CITY OF ALBUQUERQUE

October 7, 2022

Re: Champion Xpress
5101 Lomas Blvd. NE
30-Day Temporary Certificate of Occupancy
Transportation Development Final Inspection
Architect's Stamp dated 5-11-22 (J17-D010)
Certification dated 09-08-22

DATE 5/11/2022	SHEET G3A
SCALE:

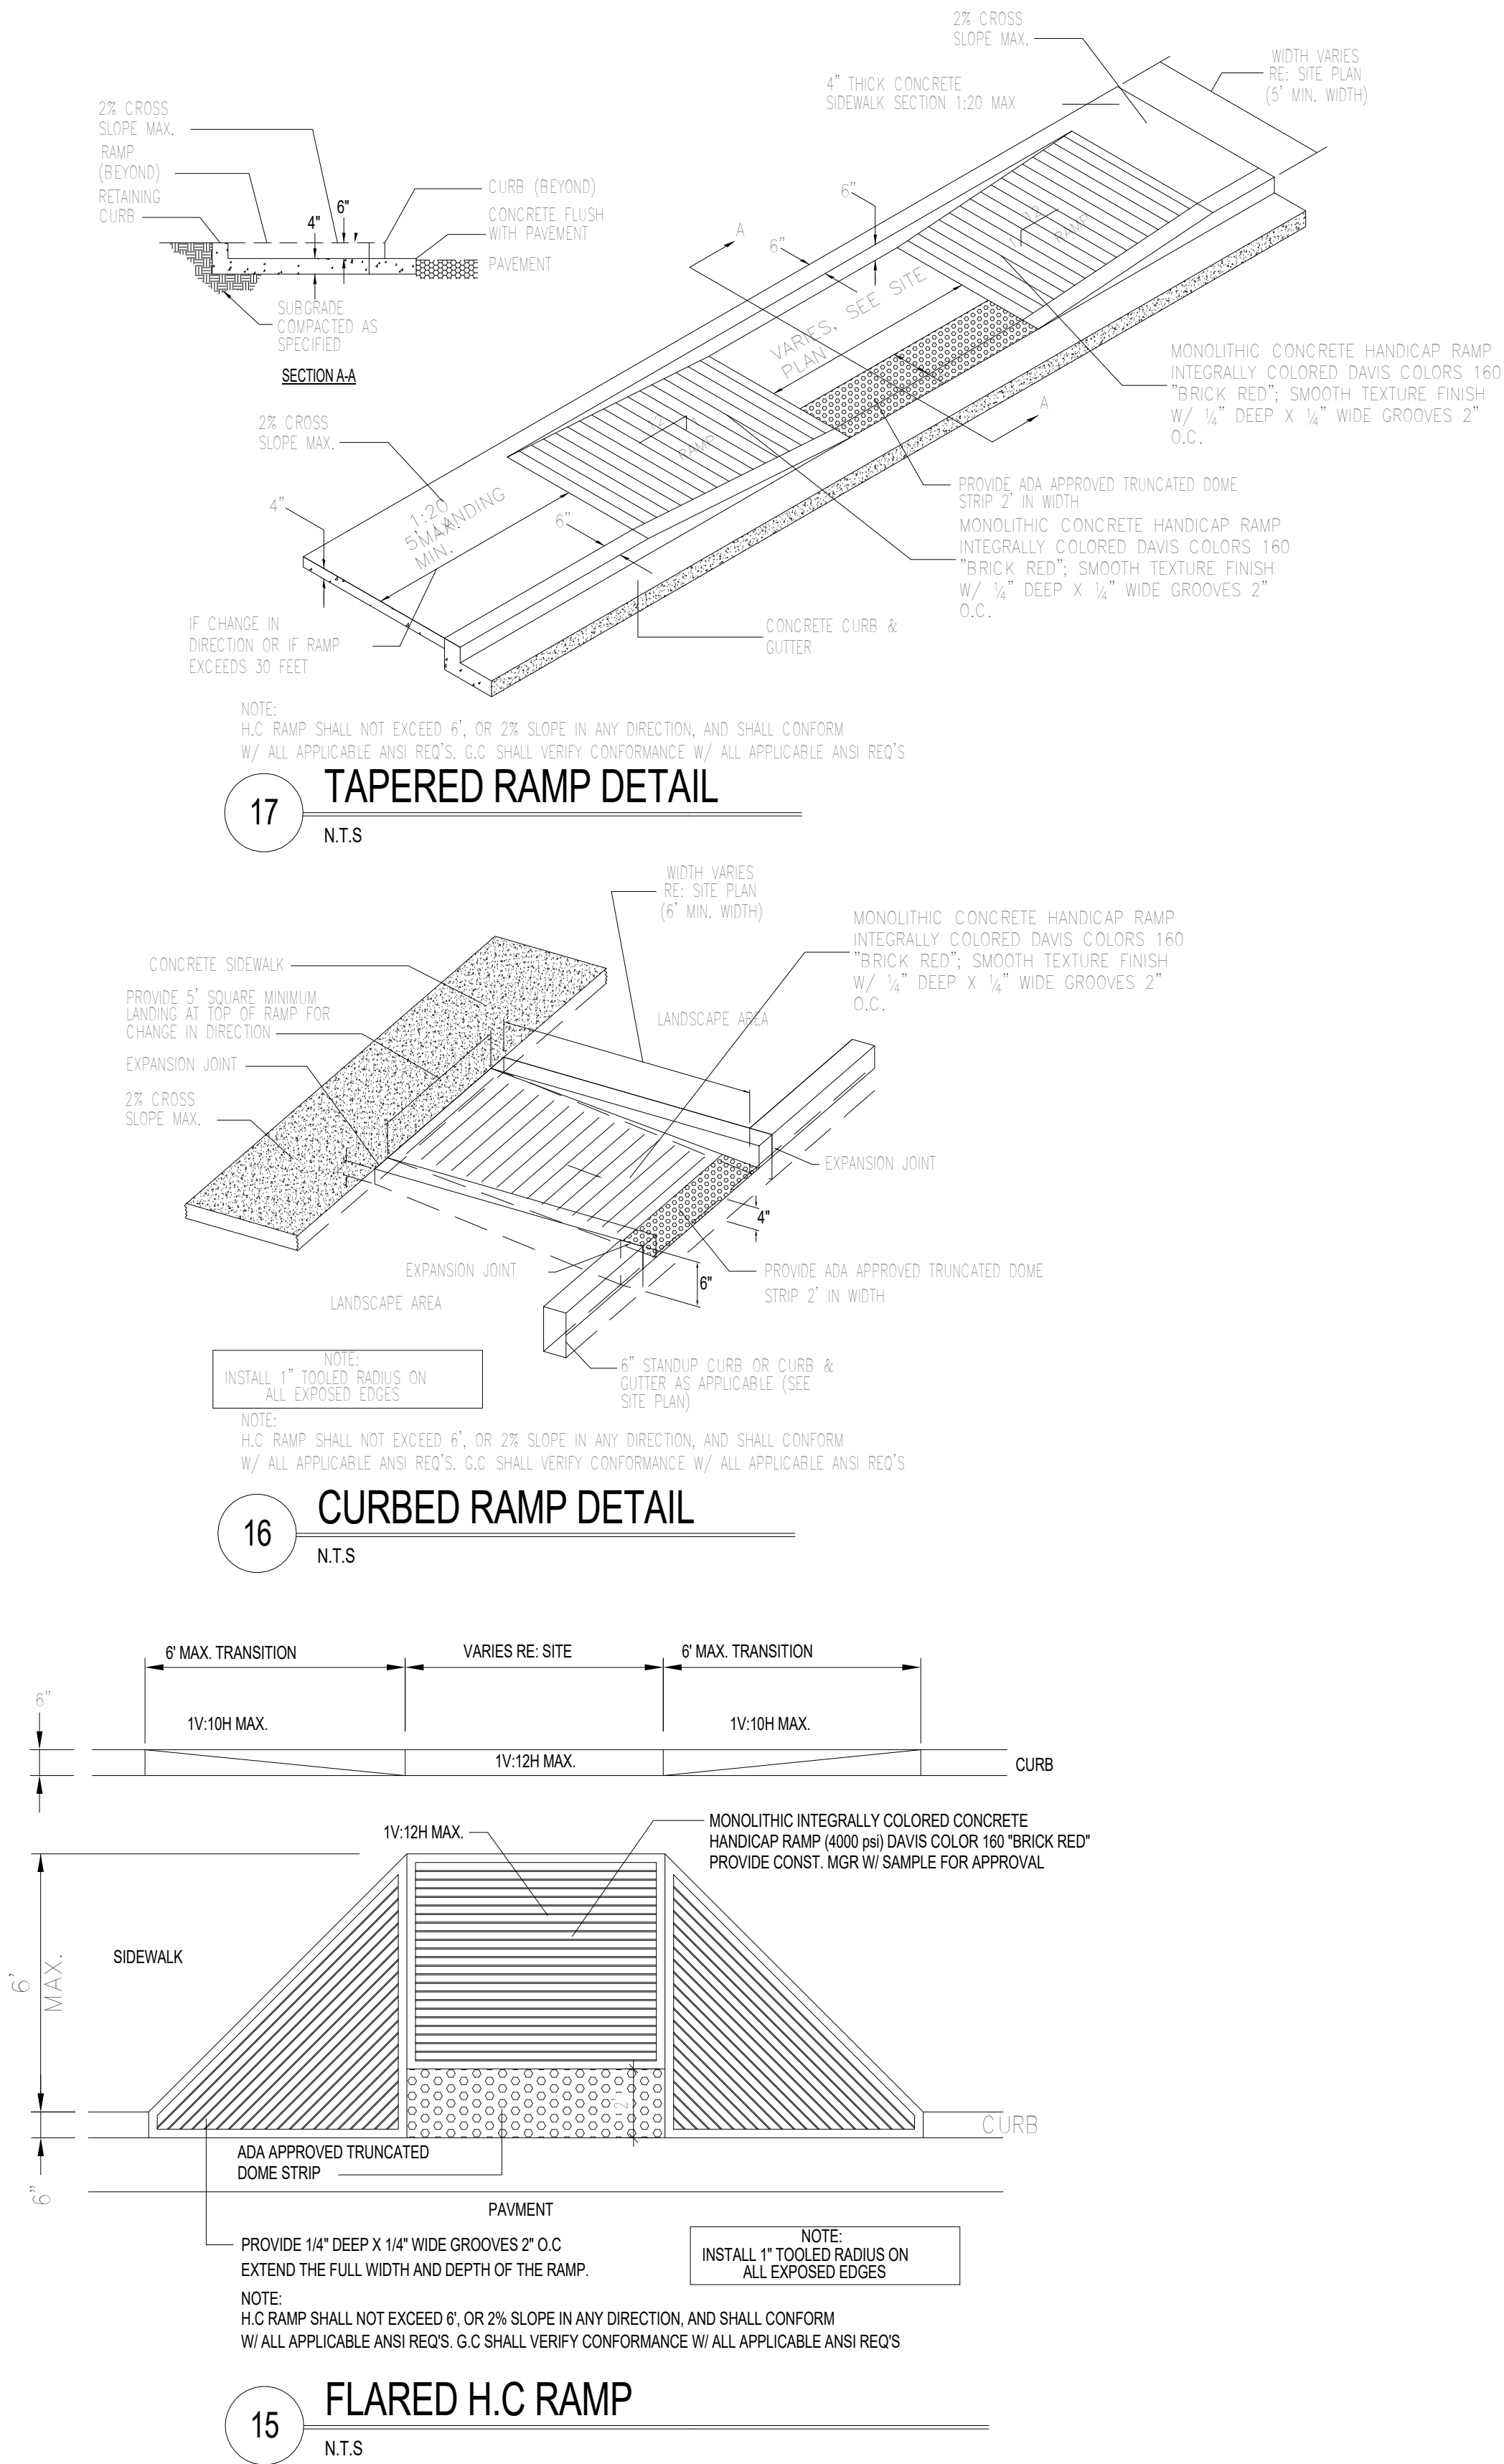
- Resubmit to PLNDRS@cabq.gov and pay the resubmittal fees.
- ADA ramp at the corner of Lomas and Manzano: please fill out the ramp with concrete (there is a gap between the truncated domes and the curb) to be flush with asphalt to avoid tripping hazard.
